CITY OF ALBUQUERQUE

December 11, 2015

**RE: Chick-fil-A on Wyoming
2274 Wyoming Blvd. NE
Requested for 30 Day Temporary C. O. - Accepted
Engineers Stamp Date 6/23/15 (H20D003C)**

**C-3.0**

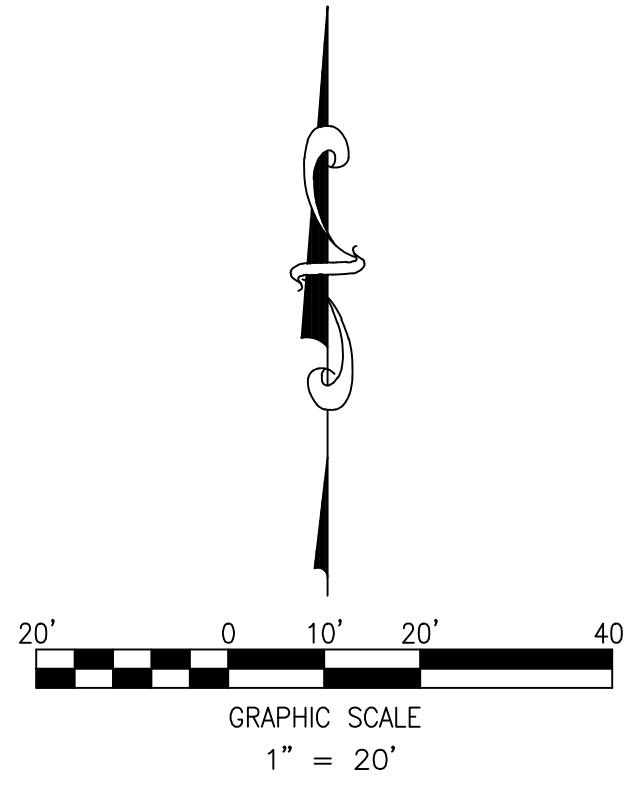
- The pond on the southwest corner must be completed.
- The pond on the west side must be completed.
